# OXFORDSHIRE COUNTY COUNCIL'S RESPONSE TO CONSULTATION ON THE FOLLOWING DEVELOPMENT PROPOSAL

**Application no:** 22/03063/F

**Proposal:** Erection of 126 dwellings with access from Camp Road, provision of public open space and associated infrastructure.

**Location:** Land East Of Larsen Road, Heyford Park

SINGLE GARAGE

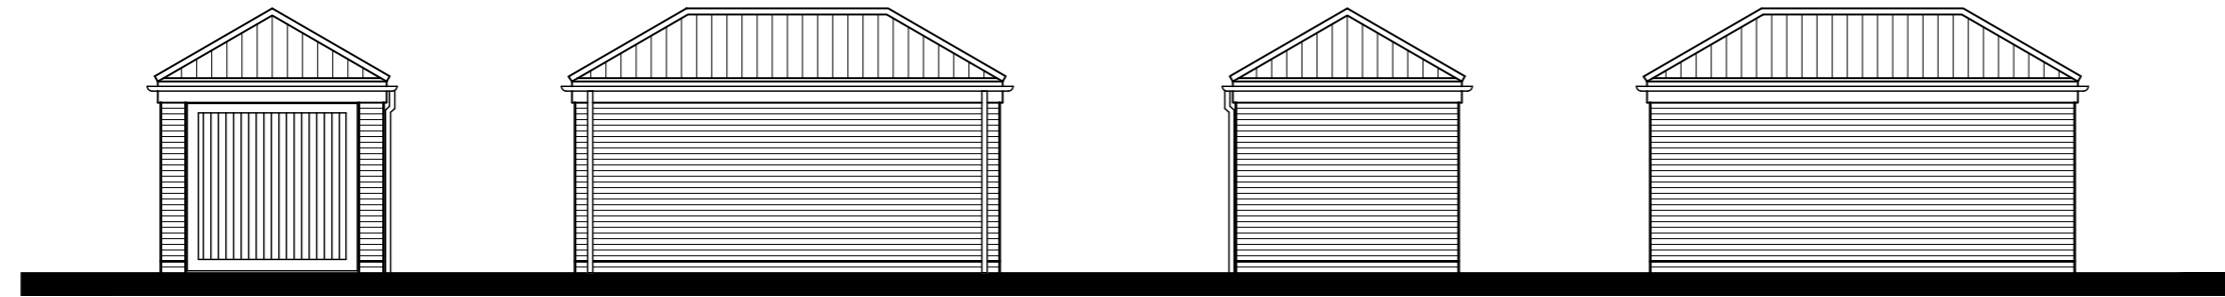
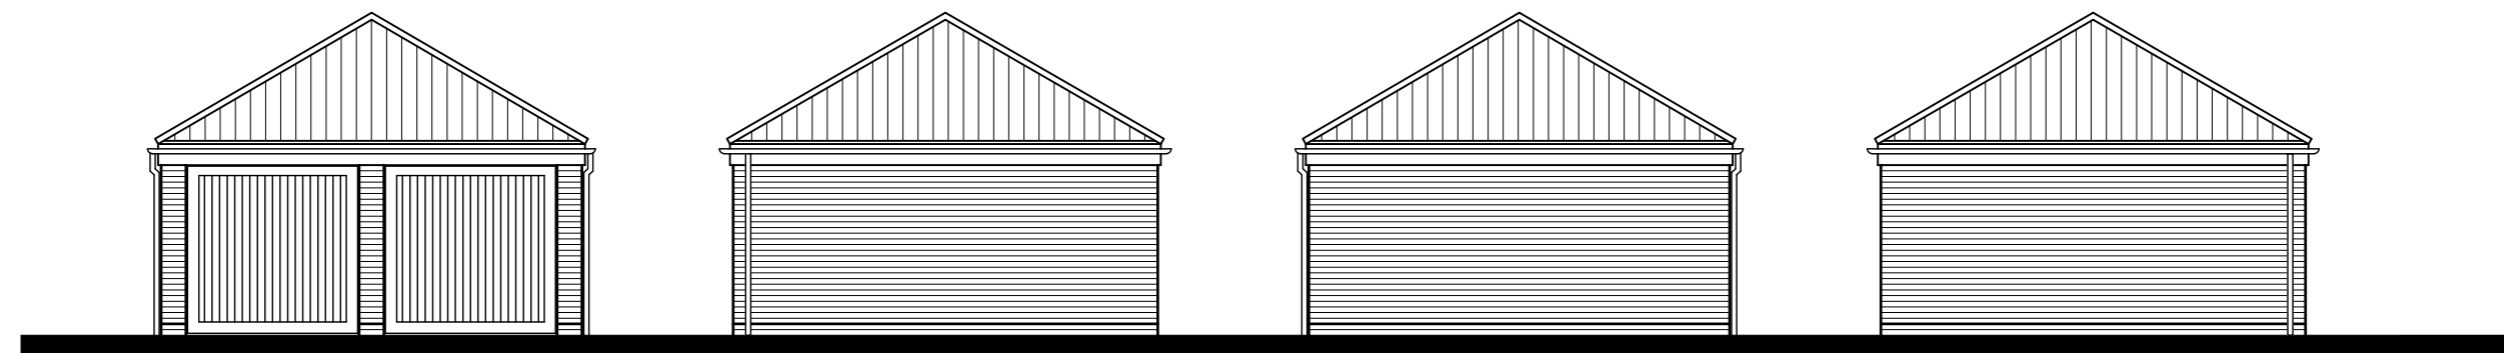
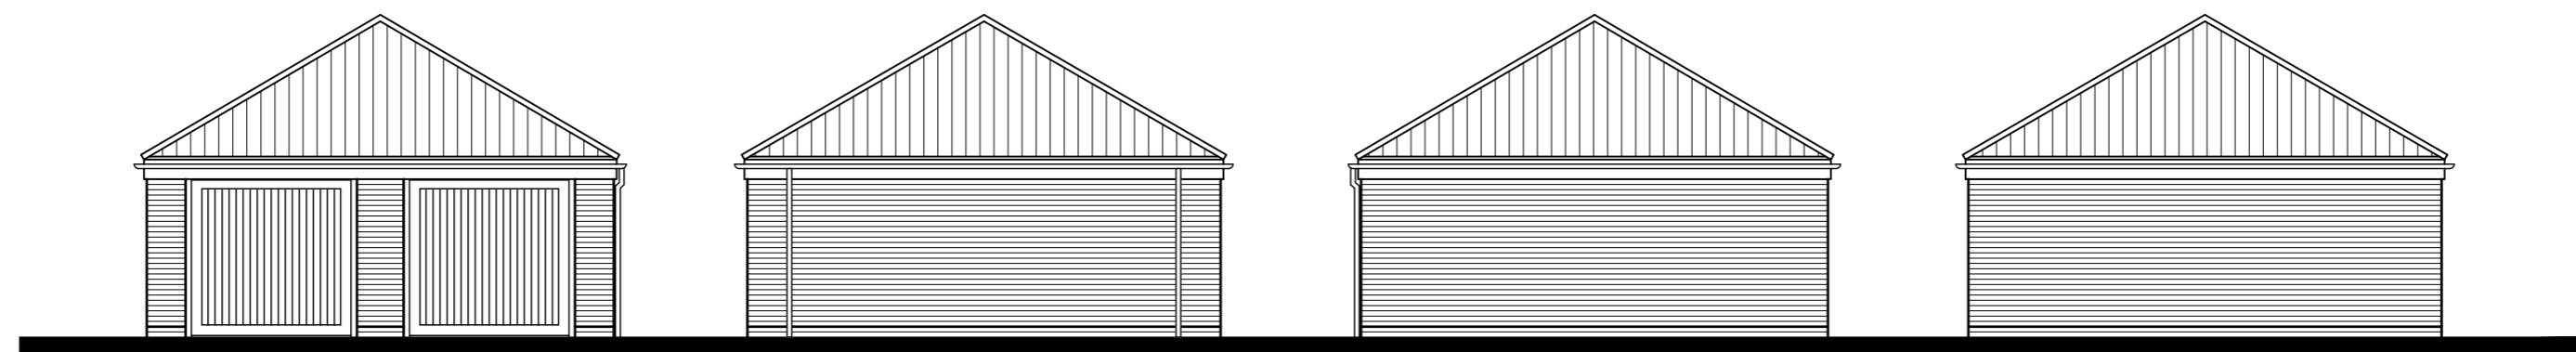
It can be seen that 2-, 3- and 4-bedroom dwellings may have a maximum of two spaces, which would tally with the number of Bays listed in the Parking Matrix document. However, as the garages have minimum internal dimensions of 6.0m x 3.0m, they are also to be counted as parking spaces. This results in 51 dwellings having three parking spaces each and exceeding the adopted standards, which is a reason for objection.

Engineering Plan

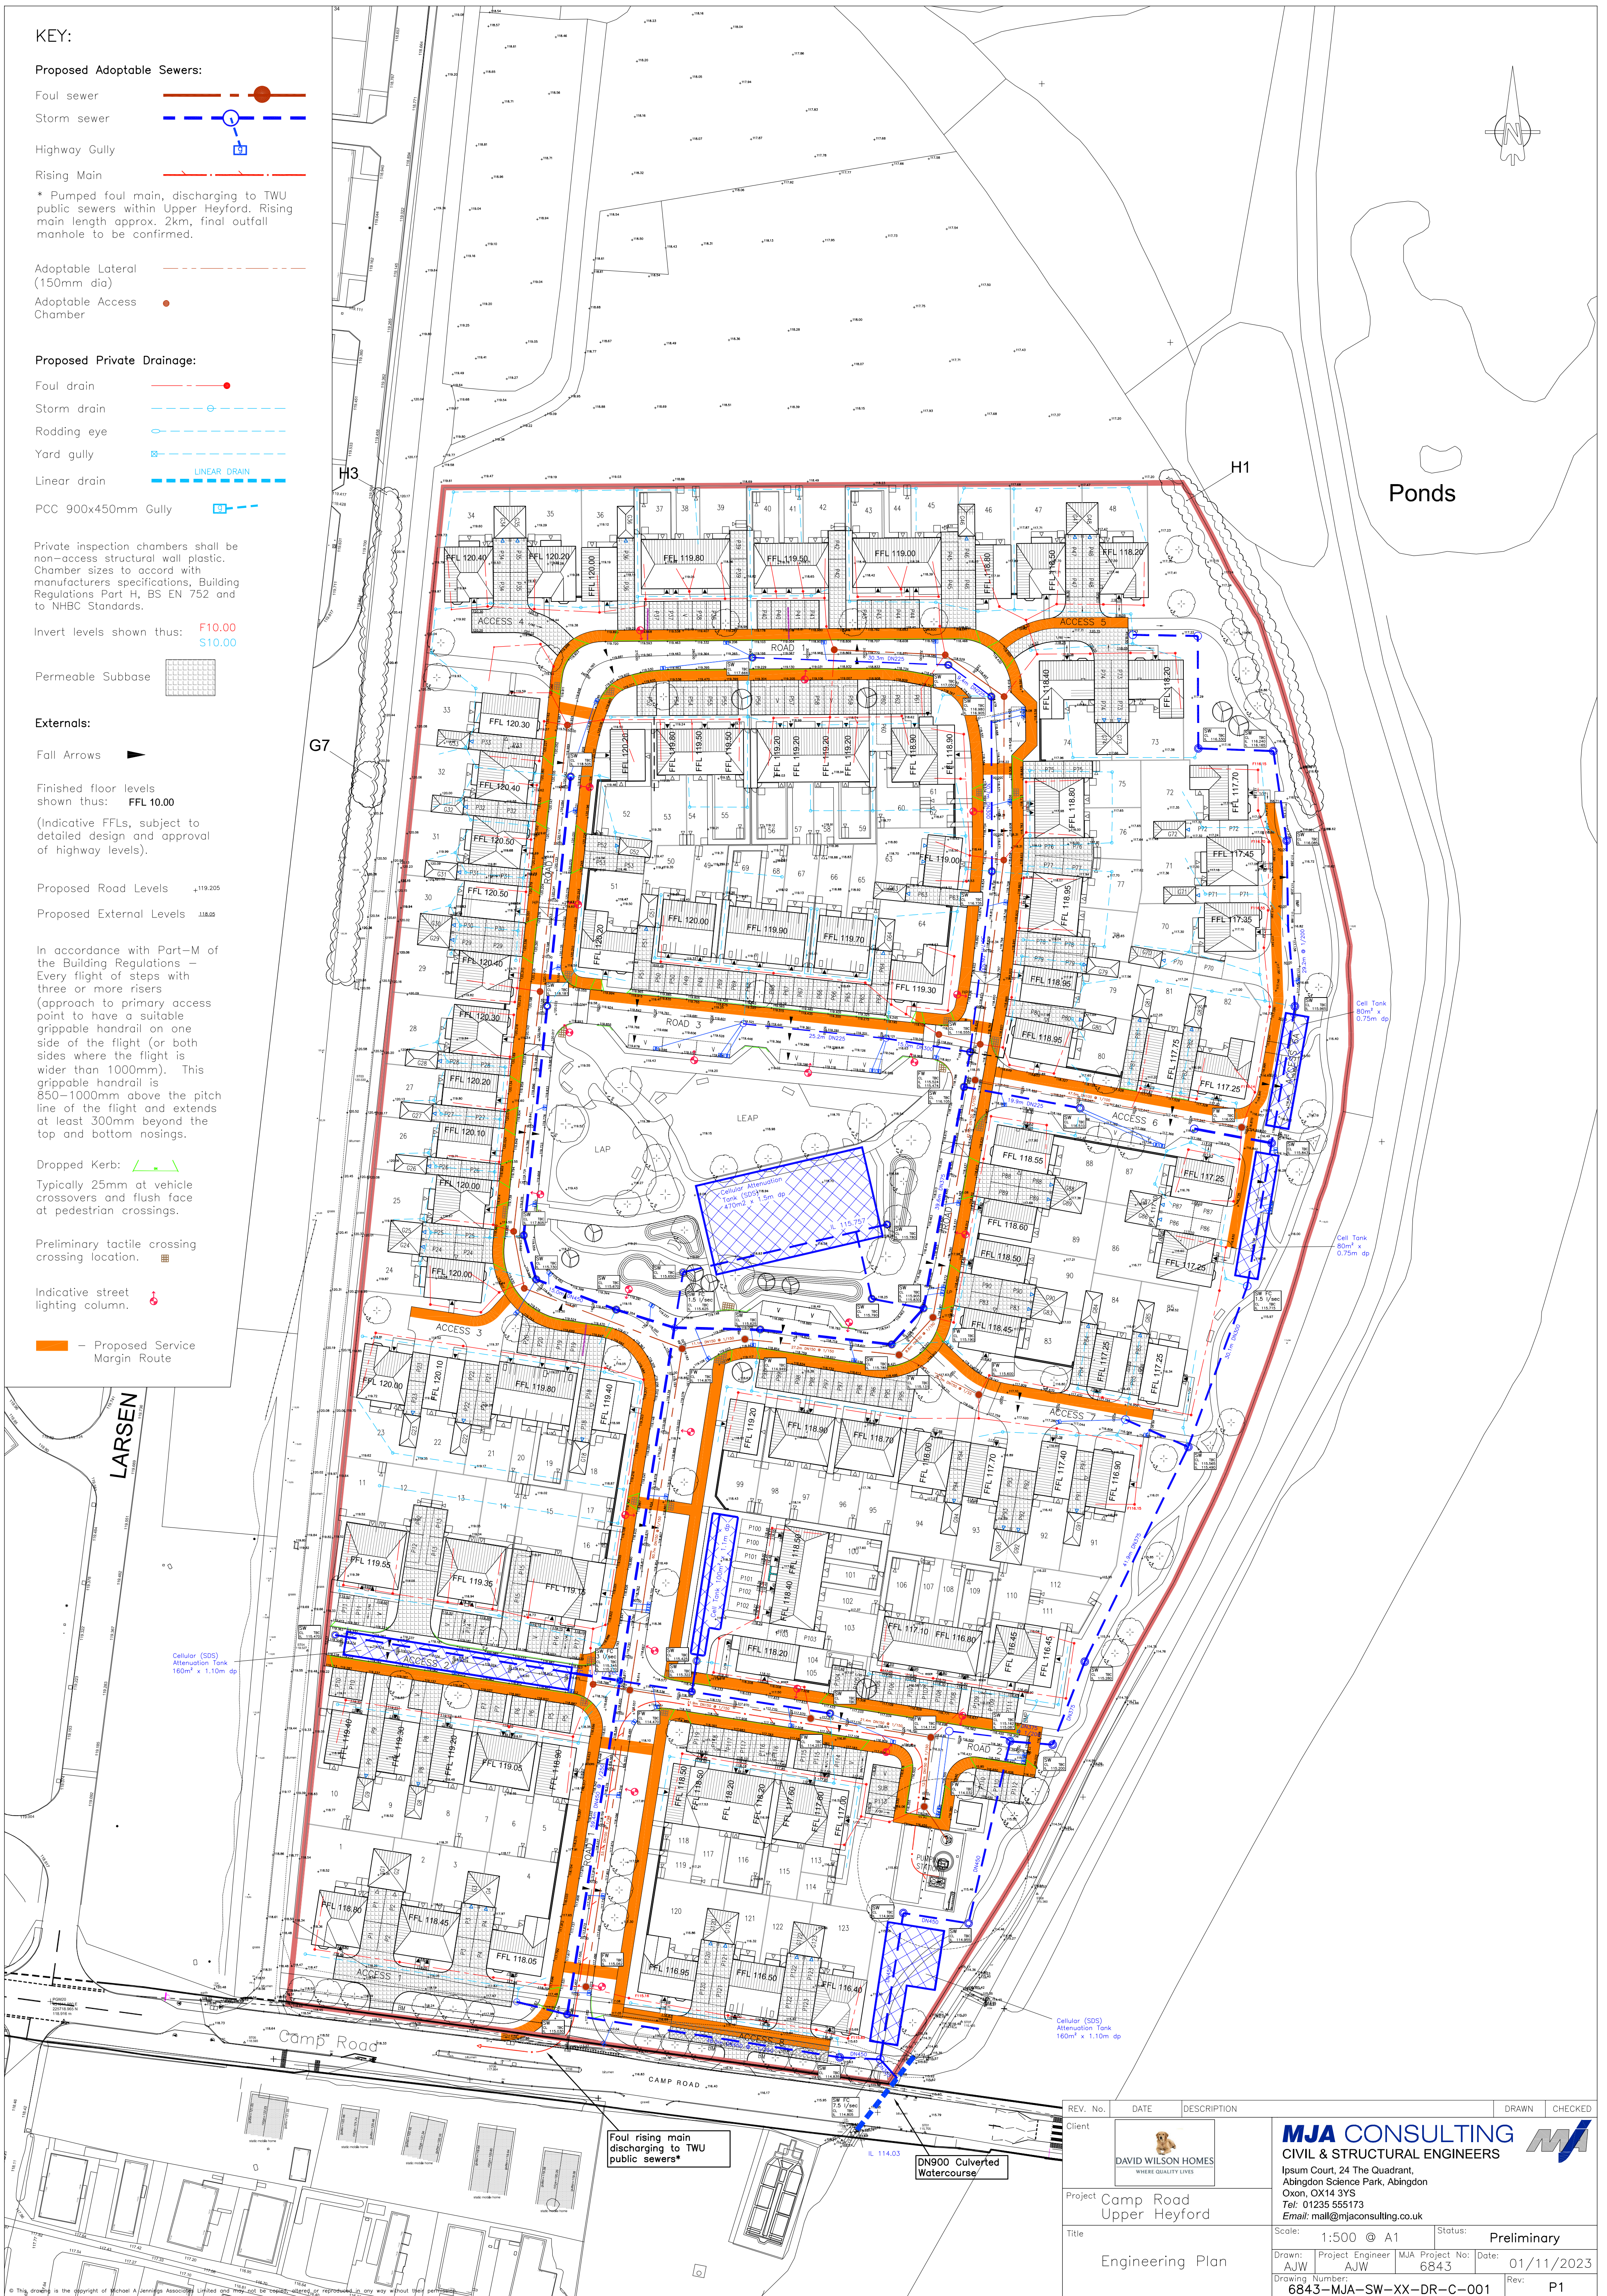
All the drainage infrastructure around the private plots needs to be shown. Provide invert and cover levels of all SuDS/drainage infrastructure. Include pipe gradients and pipe numbering which should read in line with the calculations.

Surface water from the development can't be discharged into a highway system, highways systems will only take run off from highways only. Provide correspondence from the highway authority.
